**WELWYN HATFIELD BOROUGH COUNCIL  
EXECUTIVE DIRECTOR - PLANNING, PUBLIC PROTECTION AND GOVERNANCE**

**Application No:** 6/2020/2141/HOUSE  
**Location:** Nyn Manor Vineyards Road Northaw Potters Bar EN6 4PQ  
**Proposal:** Replacement entrance gates  
**Officer:** Mr David Elmore

**Recommendation:** Refused

PROPOSED GATE ELEVATION 1/50

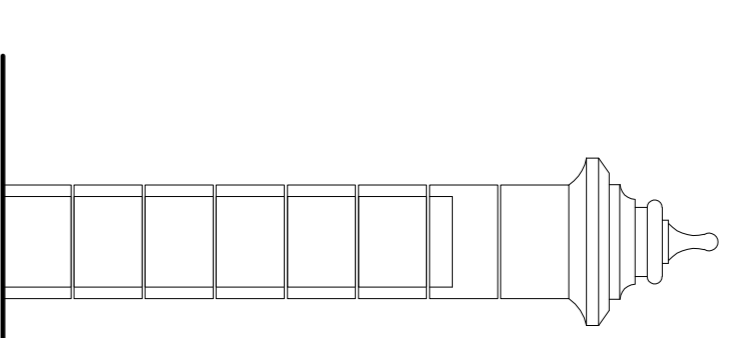
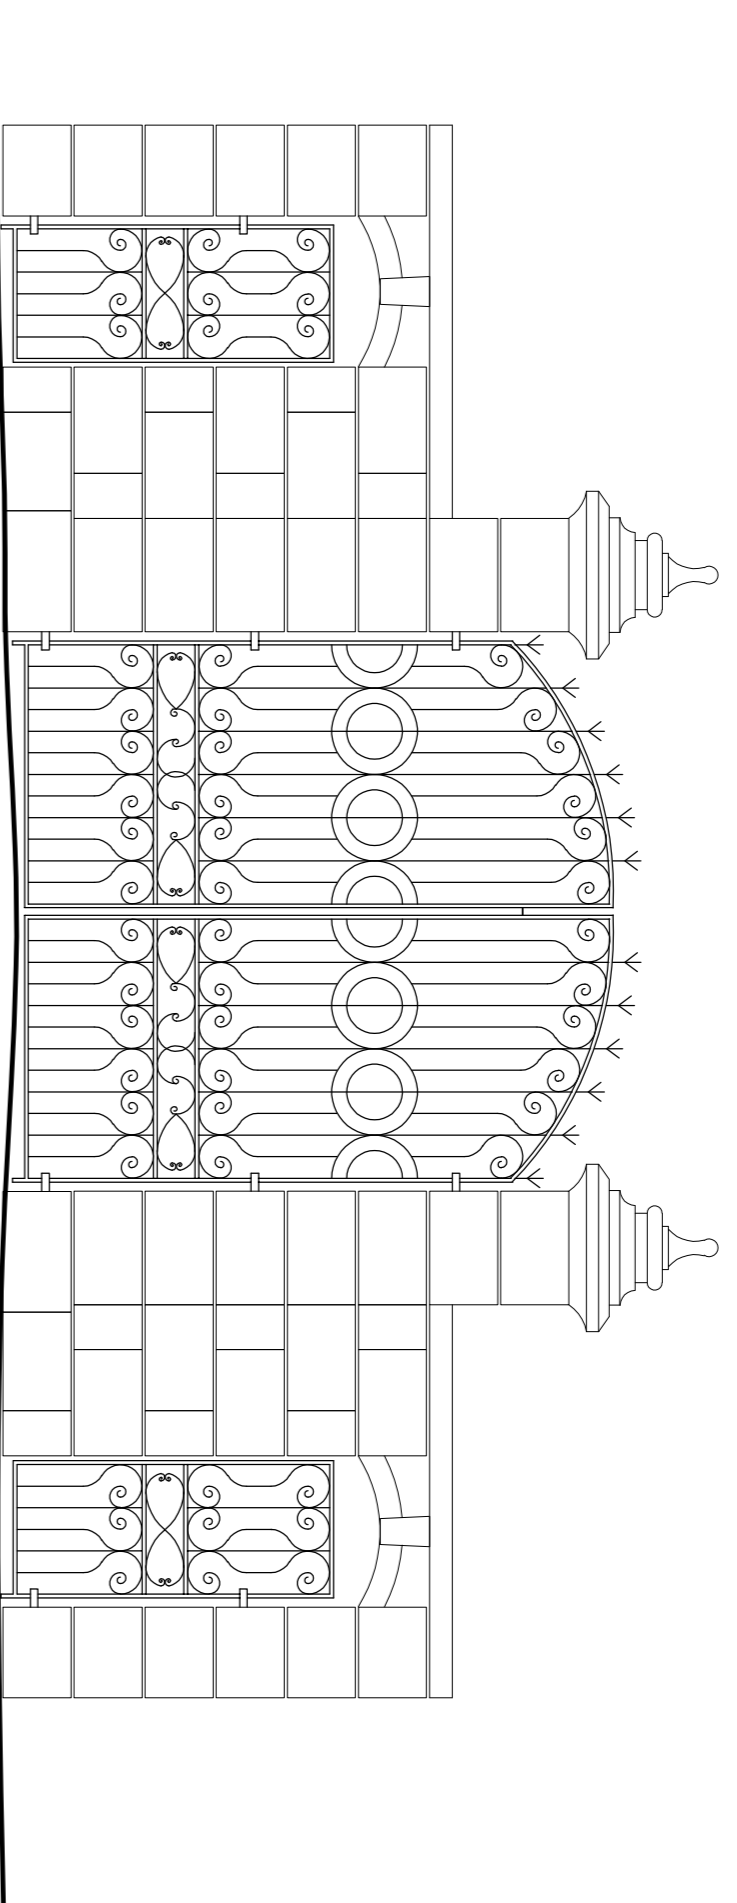
<p>gates, stone piers and a stone wall. The gates would have a height of 4 metres; the supporting piers would have a height of 4.7 metres, width and depth of 0.75 metres; the wall would have a height of 3 metres and depth of 0.6 metres.</p> <p>Unlike the existing gates and fencing, the proposed structure would be a large and solid structure with a grandiose appearance. Its height and depth would be significantly greater than existing and it would very bulky in comparison to the existing gates and fencing. Its size and appearance would also make it very prominent when passing on foot along Vineyards Road and on approach.</p> <p>For these reasons, it is considered that the proposed building would be materially larger than the one it would replace and, therefore, represent inappropriate development in the Green Belt.</p> <p><i>Openness</i></p> <p>The existing gates and fencing allow clear views through to open land beyond. This permeability would be significantly reduced through the introduction of the solid walls and piers and ornamented gates. This factor, together with the increase in scale, bulk and prominence of the proposed development, would result in a material loss of Green Belt openness.</p>

<p><b>Design (form, size, scale, siting) and Character (appearance within the streetscene)</b></p>	<p>Policies D1 and D2 of the Welwyn Hatfield District Plan 2005 respectively require high quality design in all new development and for proposals to respect and relate to the character and context of their location, maintaining and where possible enhancing the character of the existing area. These policies are expanded upon in the Council's SDG which outlines that new development must sensitive to local character.</p> <p>The NPPF advocates high quality design and that permission should be refused for development of poor design which fails to take the opportunities available for improving the character and quality of an area the way it functions, taking into account any local design standards or style guides in plans or supplementary planning documents.</p> <p>The site and immediate locality has a rural character and the gated entrance provides access to a farmhouse with associated farmyard and agricultural buildings. There is sporadic development in the vicinity along Vineyards Road and the entrances to some properties do include hard boundary treatments. Such hard boundary treatments are however considerably smaller in scale than the proposal and do not have an imposing appearance.</p> <p>It is considered that the scale and grandiose style of the proposed structure would be in stark contrast to the traditional agricultural character of the site and its rural setting. The proposal would also be at odds with other hard boundary treatments in the area. It would appear as an incongruous addition and would fail to respect or relate to the area's character, in conflict with the above policies.</p>

1. The proposed structure would represent inappropriate development in the Green Belt and result in a loss of Green Belt openness. Consequently, the development would fail to accord with Policy GBSP1 of the Welwyn Hatfield District Plan 2005, Policy SADM34 of the Welwyn Hatfield Borough Council Draft Local Plan Proposed Submission August 2016 and the National Planning Policy Framework.
2. The proposed structure, by virtue of its scale, bulk and appearance, would fail to respect and relate to the area's character. It would represent an incongruous addition to the area, in conflict with Policies D1 and D2 of the Welwyn Hatfield District Plan 2005, the Council's Supplementary Design Guidance 2005 and the National Planning Policy Framework.
